RE: LP-17-00004 Commons at Dry Creek

STATE OF WASHINGTON  
DEPARTMENT OF ECOLOGY

RE: Ecology and Kittitas County site visit to The Commons at Dry Creek

SHEET CONTENTS
SITE PLAN

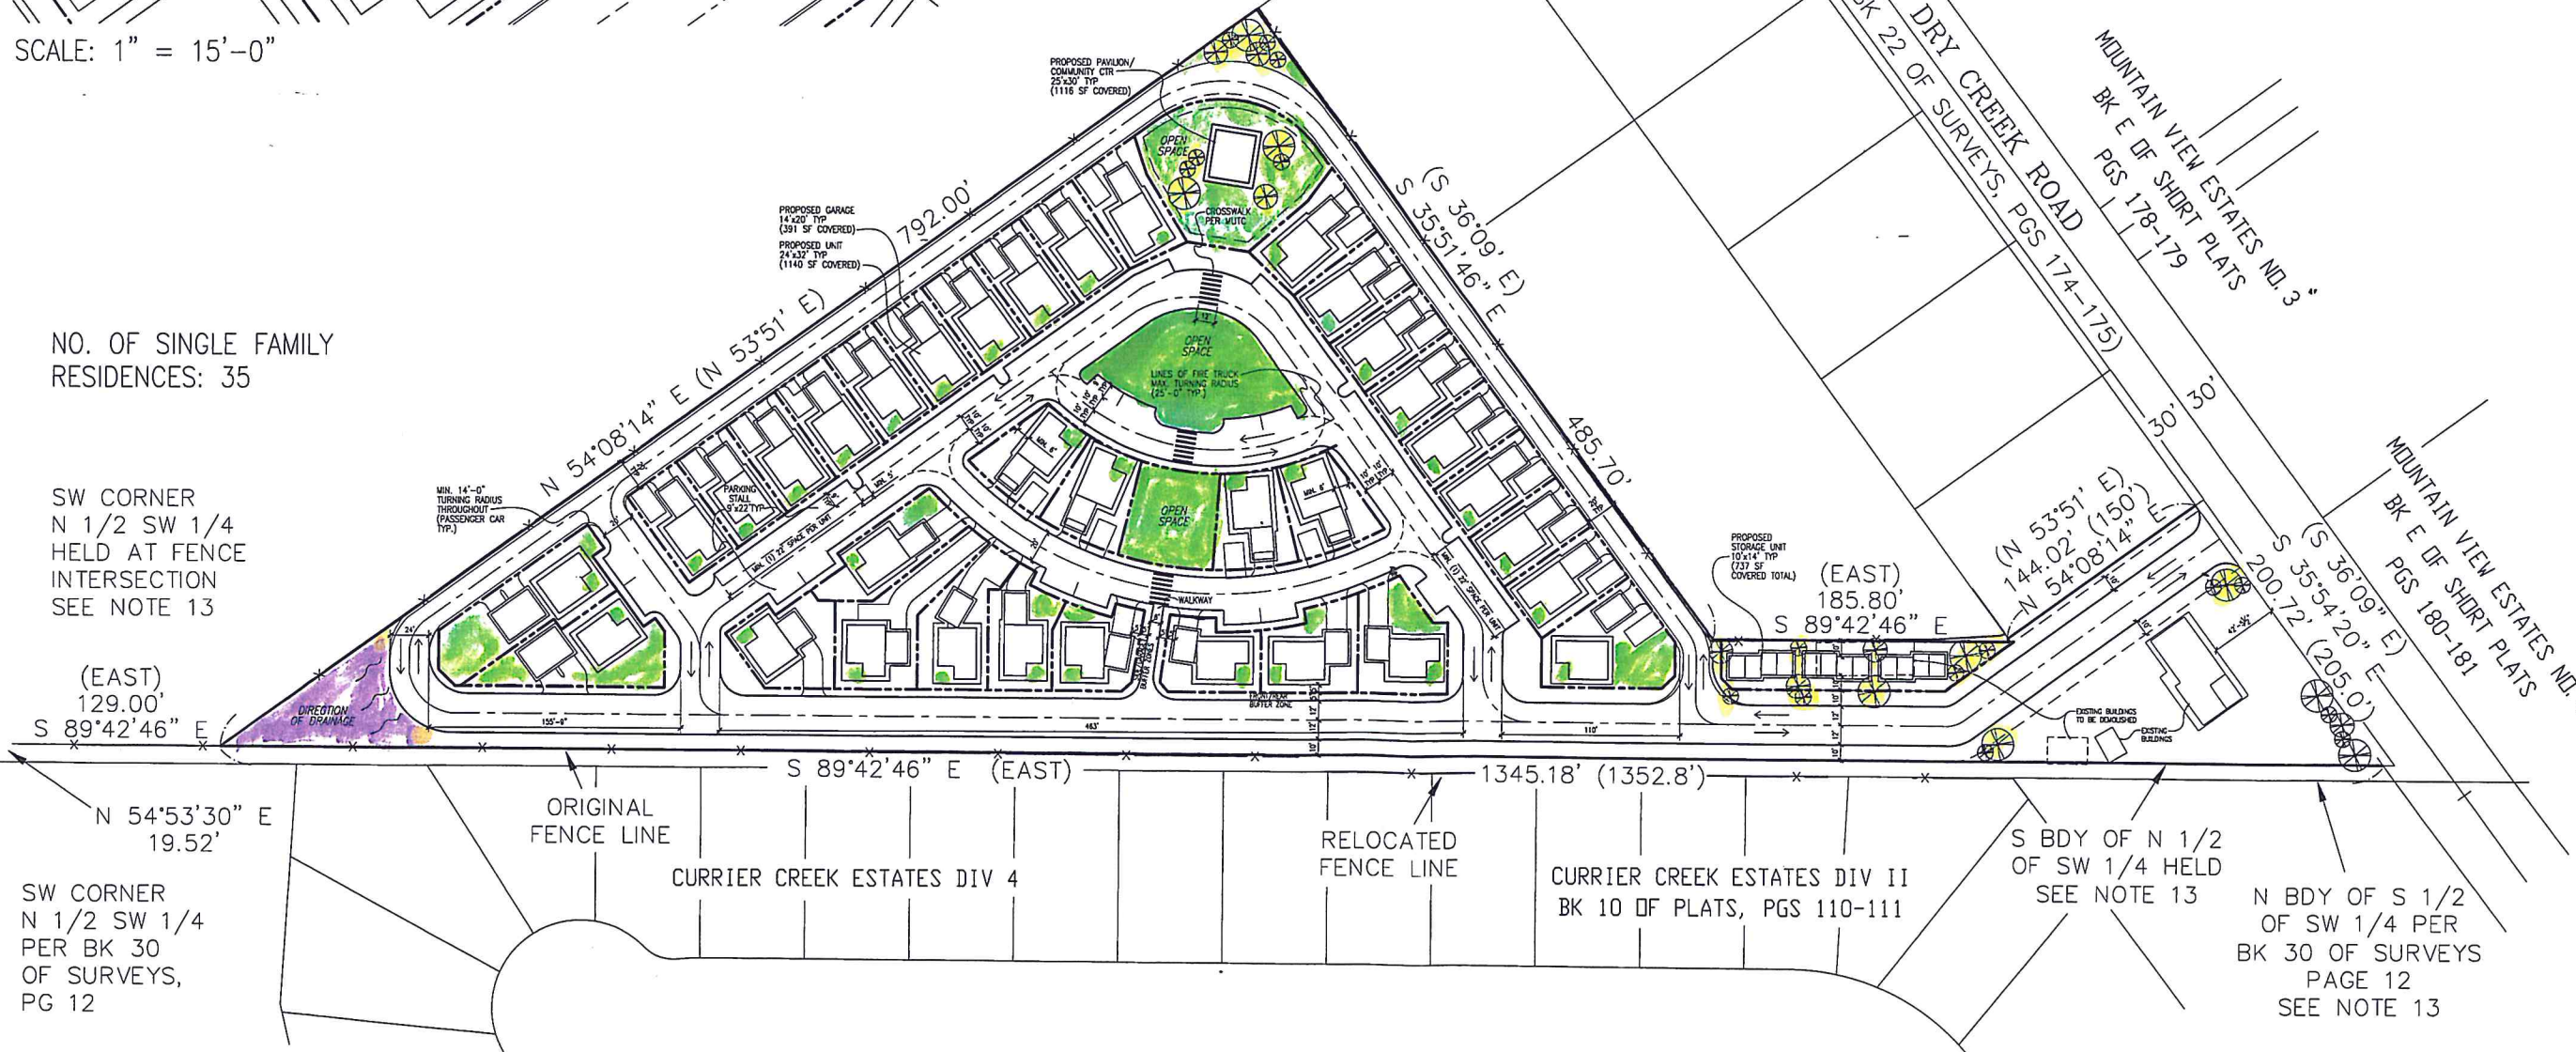
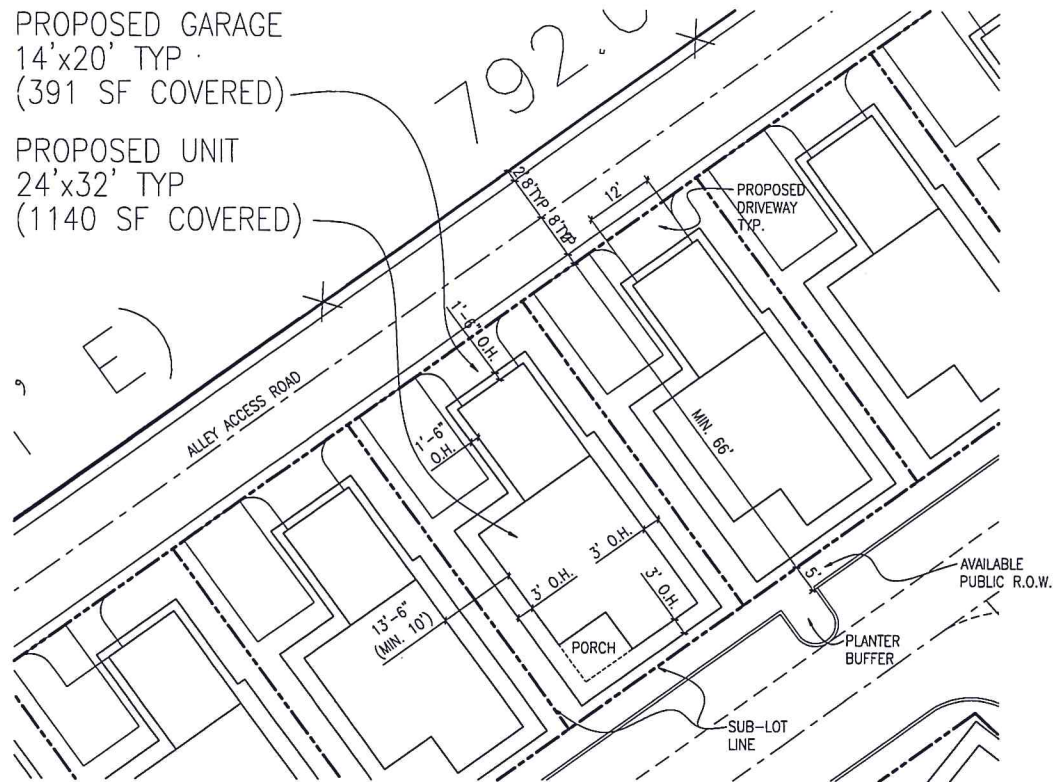
Large, dense patches of sedges (*Carex* sp.), a species typically found in wetlands and wetter growing conditions, were noted within topographic features near the center, northwest, eastern, and southern boundaries of the project site. Topographic and elevational changes were noted by Ecology staff, with topographic depressions and a topographic swale extending from the western

boundary towards the south-southwest project boundary, situated centrally through the project site.

Currier Creek is located offsite and near the western project site boundary. Ecology observed the stream corridor to contain mature forested riparian habitat. Aspen trees were noted within the riparian habitat. The presence of aspen, species that are typically found in wetter growing conditions, suggest water is present and wetland habitat may be present along the stream corridor. Wetland buffers regulated by Kittitas County may exceed stream buffer setbacks and extend onto the subject property. Ecology recommends a wetland delineation and rating of identified wetlands along the Currier Creek corridor near the project boundary, to determine potential buffer overlay onto the project site.

Prior to further review of proposed site development plans by Kittitas County, Ecology recommends a wetland delineation be conducted of the project site and adjacent Currier Creek corridor by a qualified professional using methodology according to the US Army Corps of Engineers Wetland Delineation Manual (1987) and the Arid West Regional Supplement (Version 2.0).
